Date	Project Name & #	Action Request	Action Taken
6/14/04	#1003488 Journal Center 2A-2A-3	sketch	Comments

**CITY OF ALBUQUERQUE
PLANNING DEPARTMENT
Development Review Board
June 16, 2004
Comments**

PROJECT # 1003488 APPLICATION # 04-00898

RE: Tracts 2A & 2A-3, Journal Center /sketch

94146690 PLAT OF TRACTS 2A-2A-1, 2A-2A-2 & 2A-2A-3 JOURNAL CENTER ALBUQUERQUE, NEW MEXICO

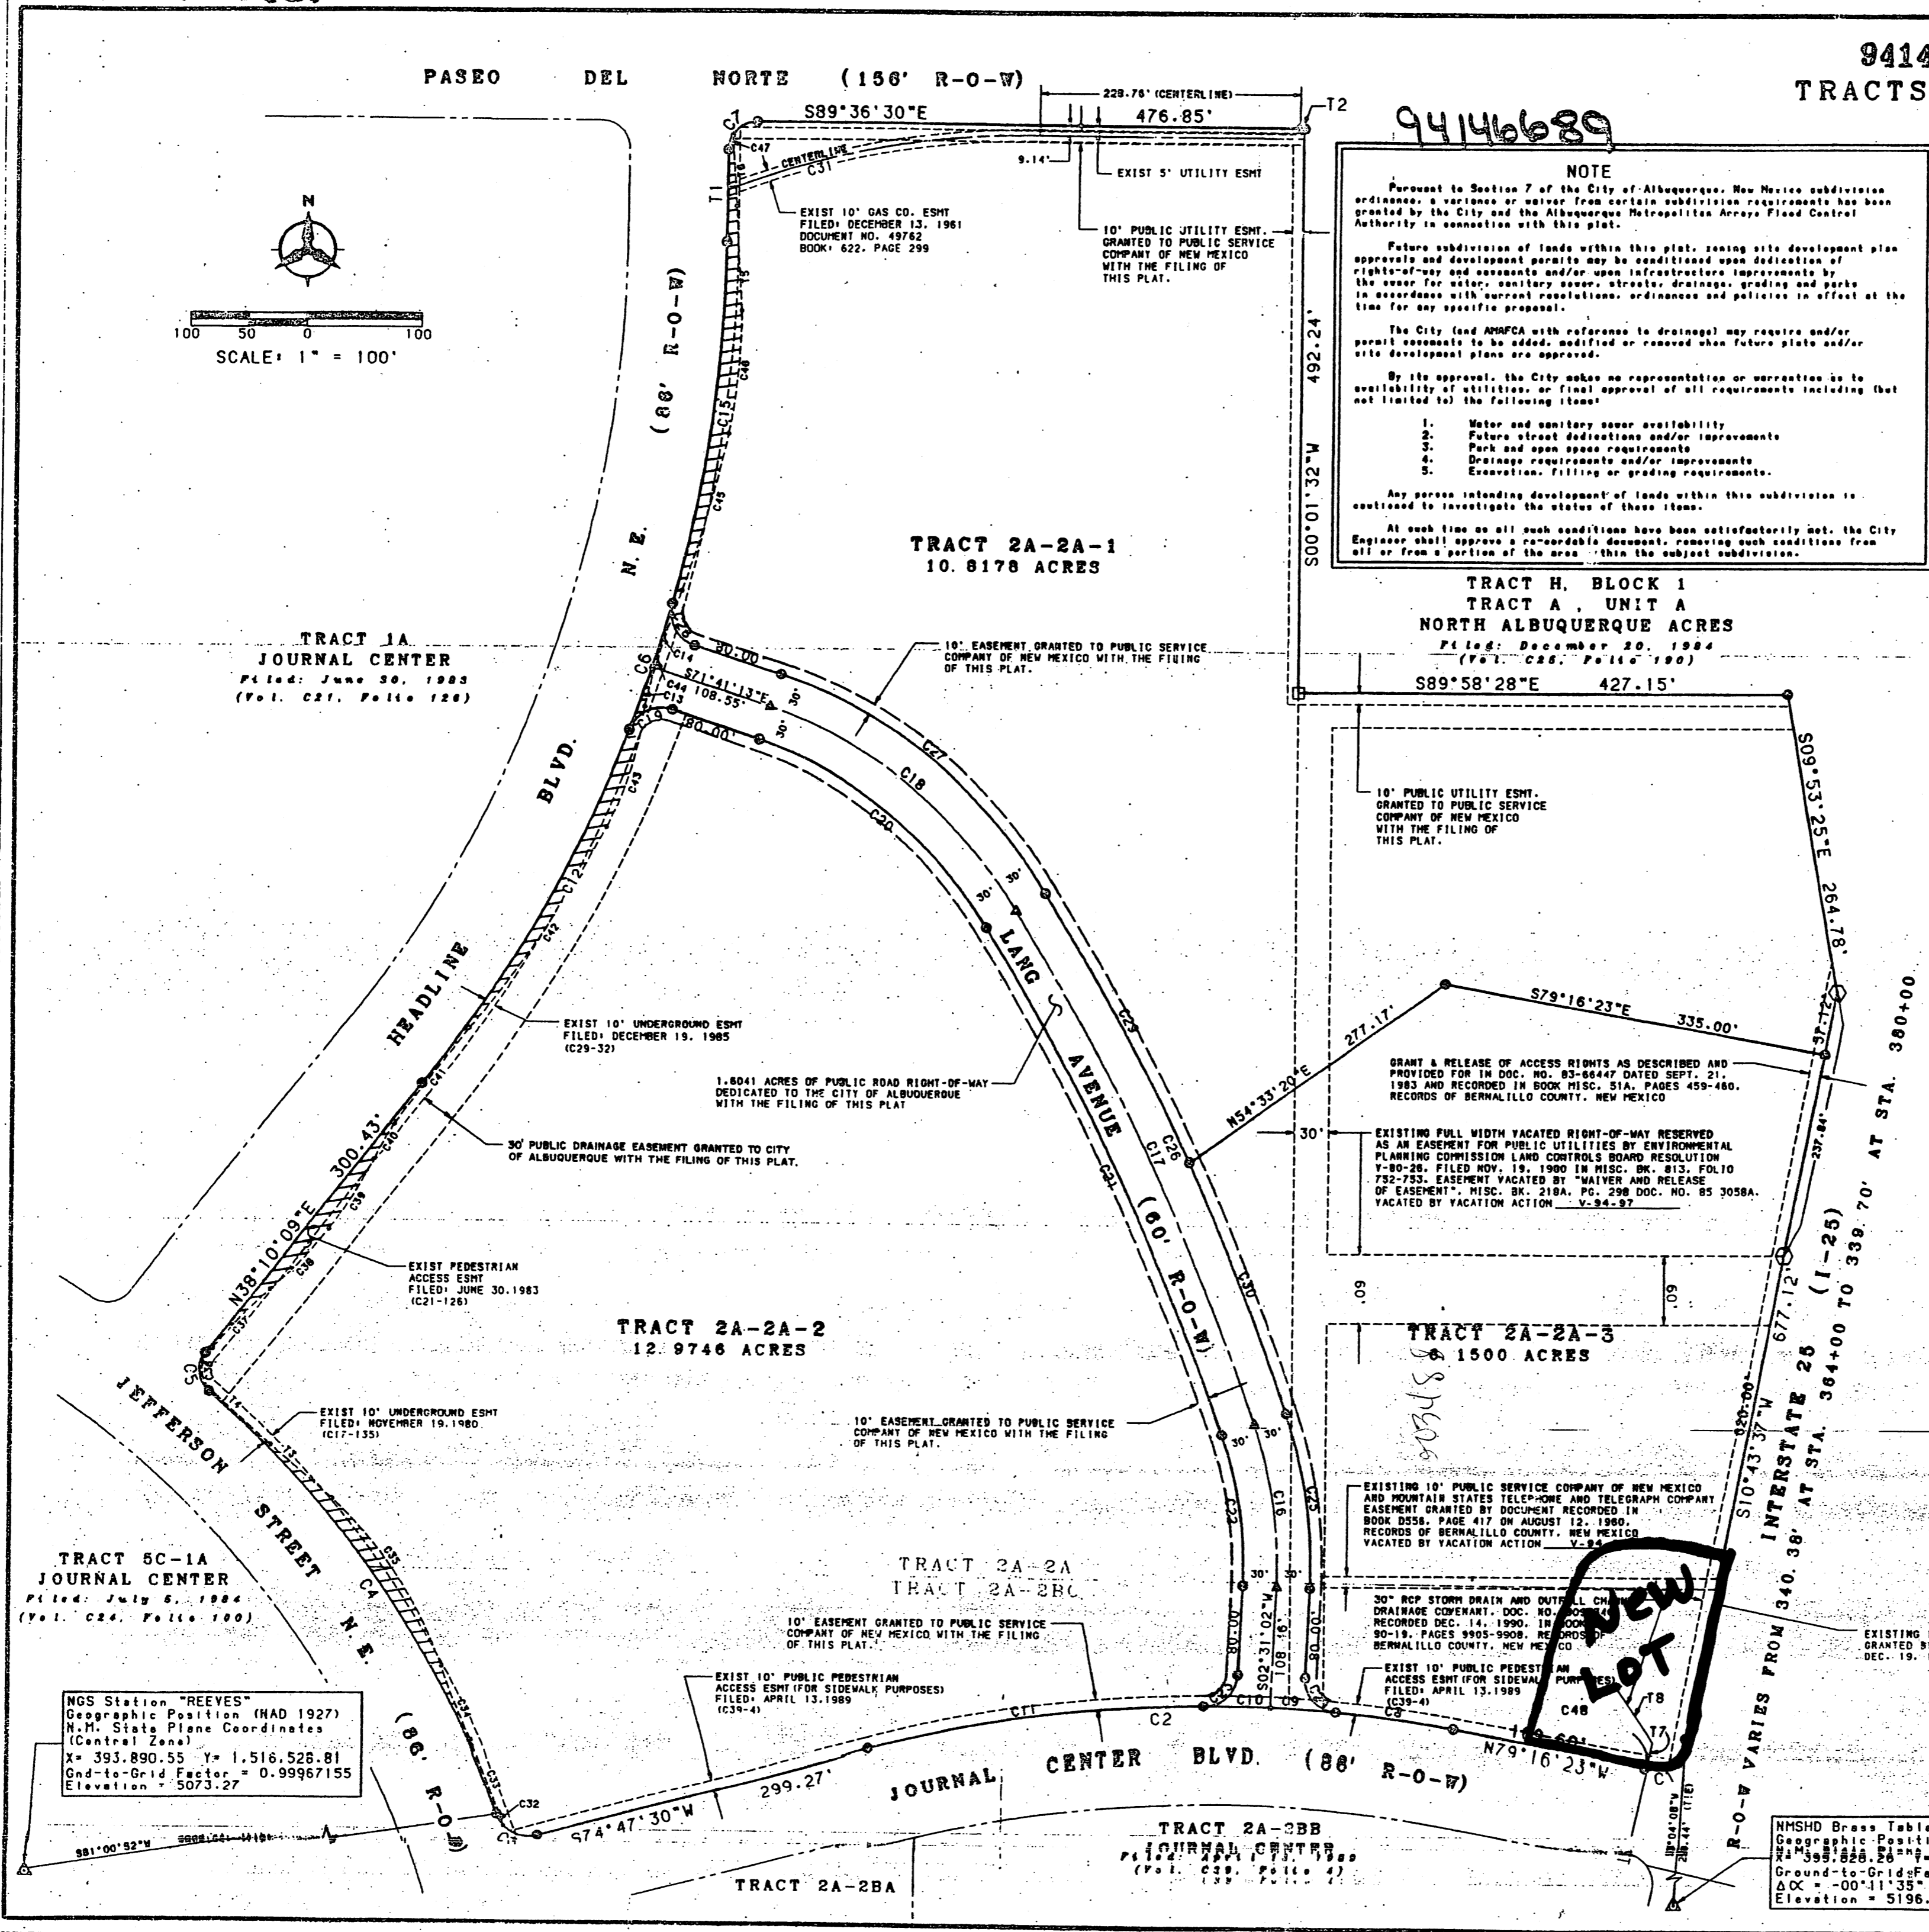
Cross drainage easement will be needed on plat.

**DIMENSIONED SITE PLAN**

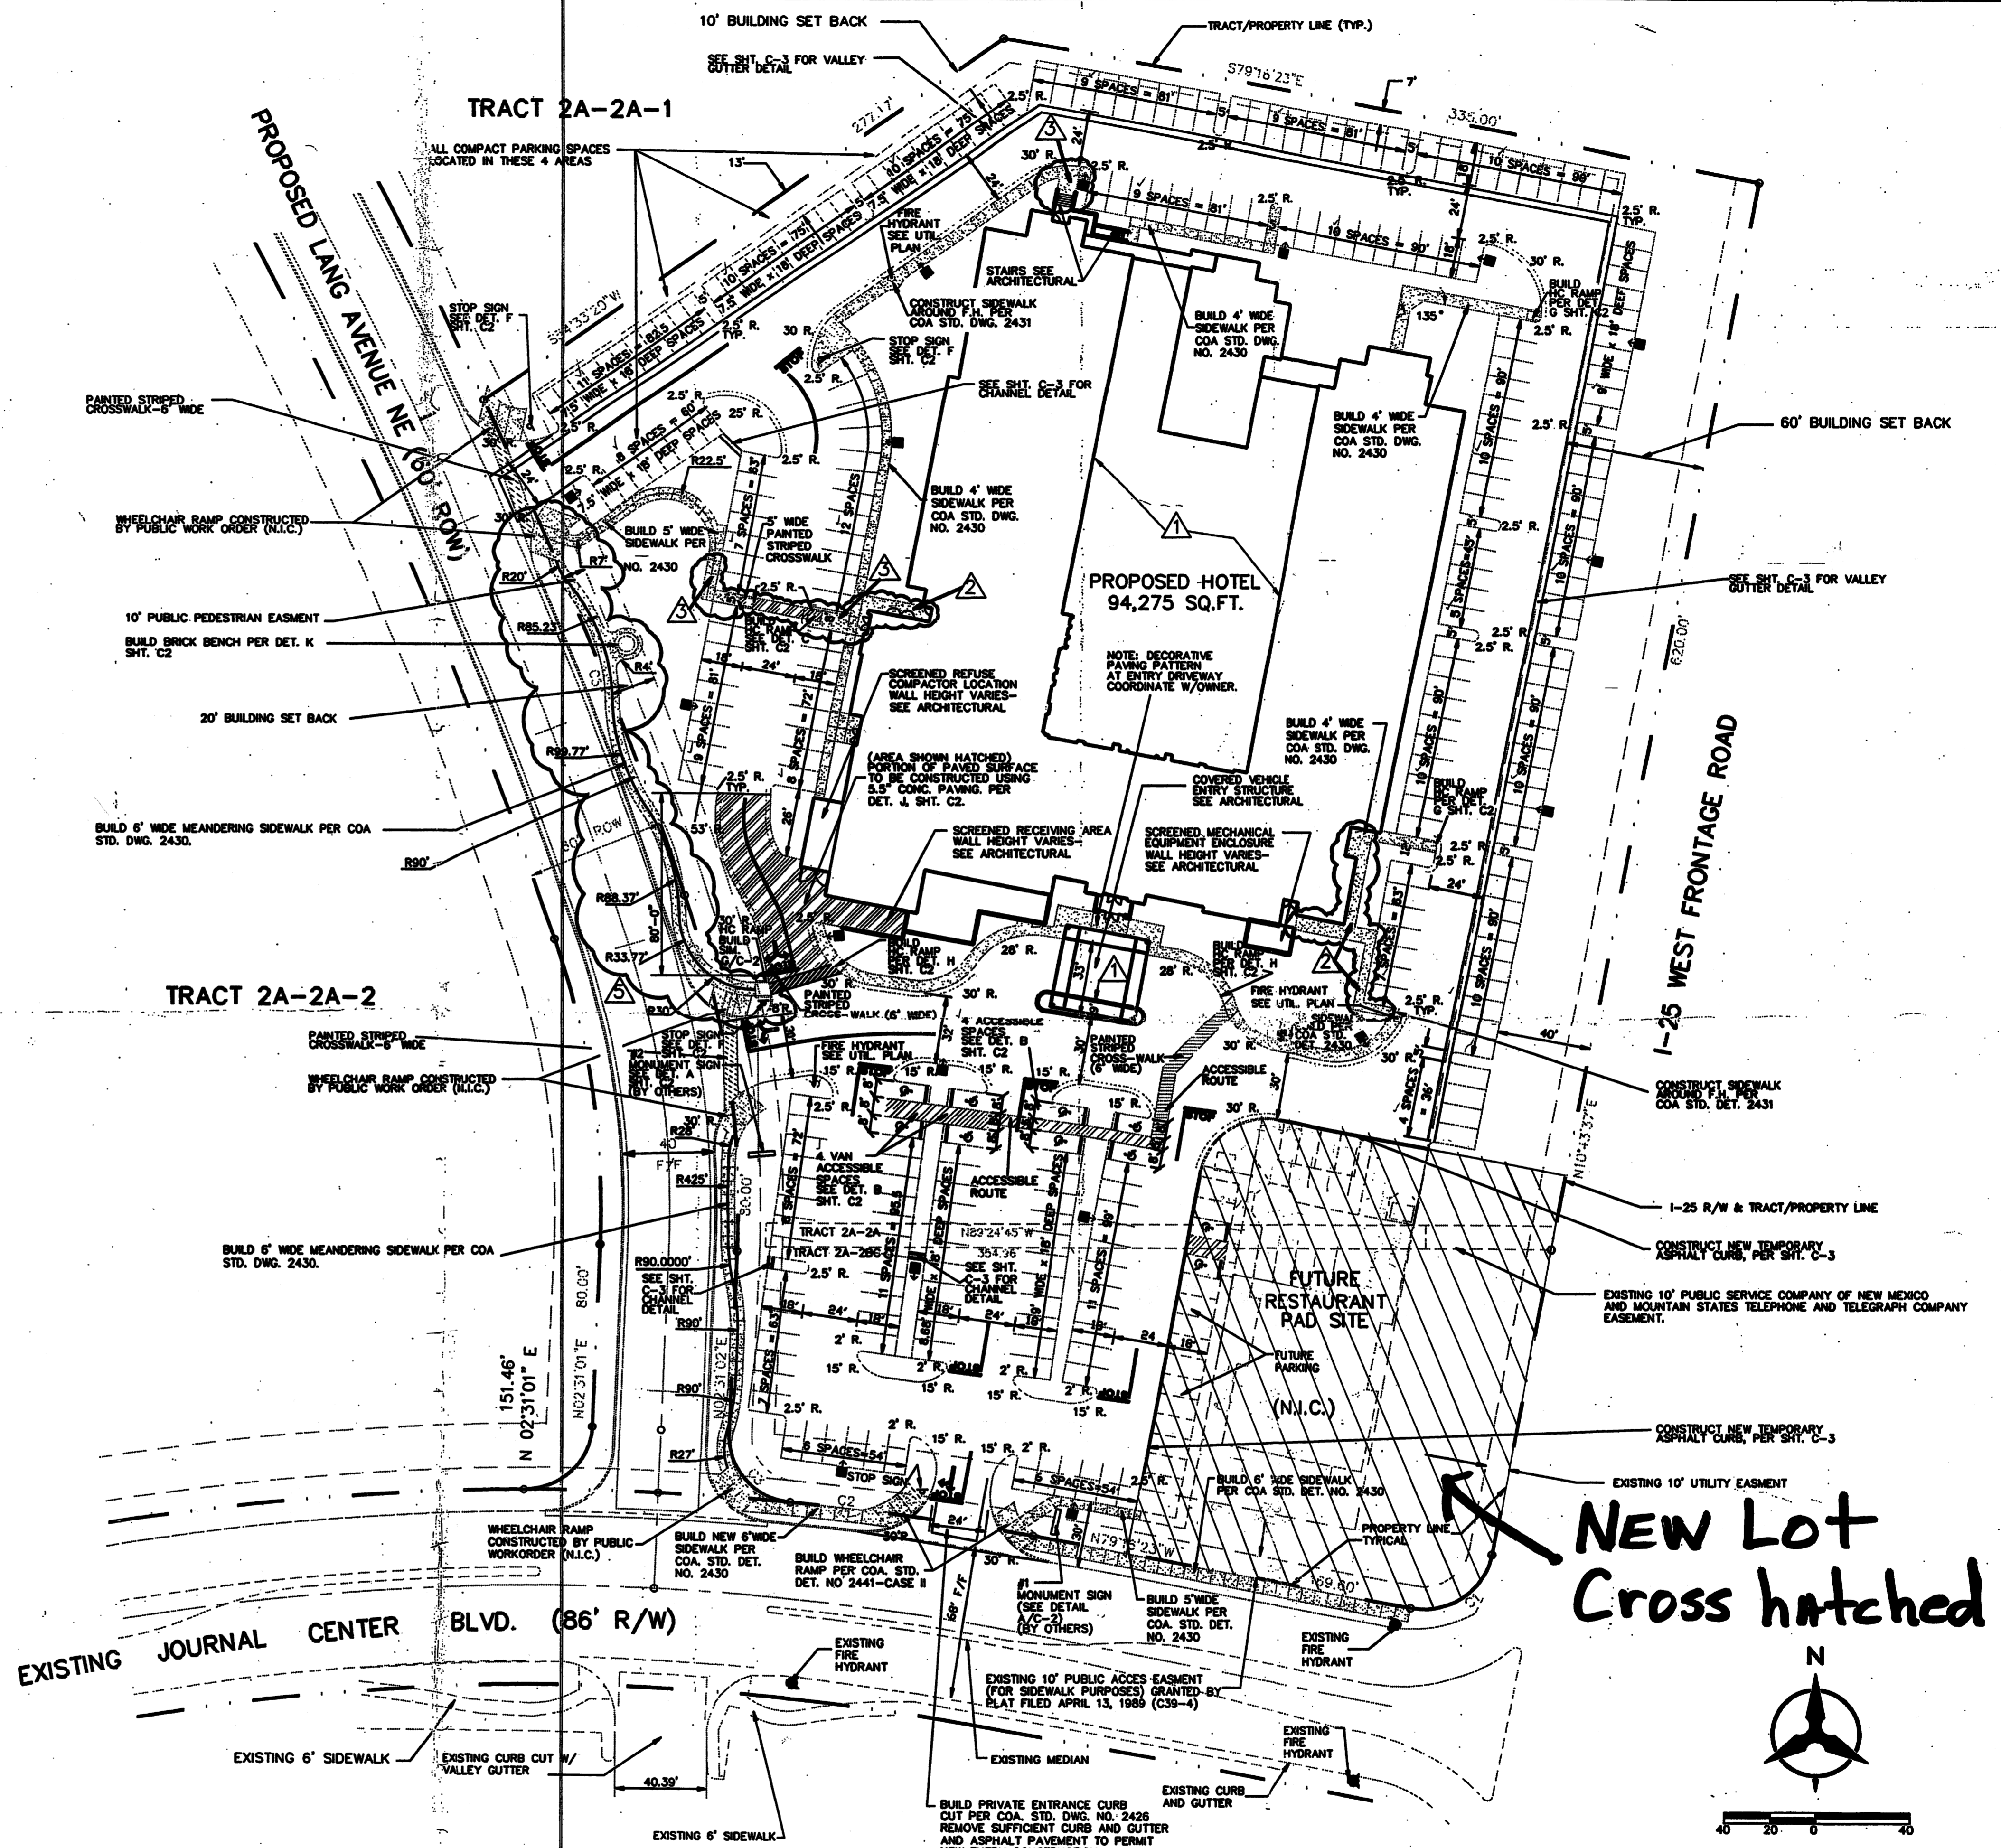
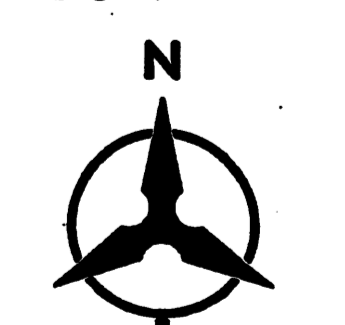
Are any of the parking spaces shown in the new lot originally parking for the hotel? What is existing now in this proposed new lot?
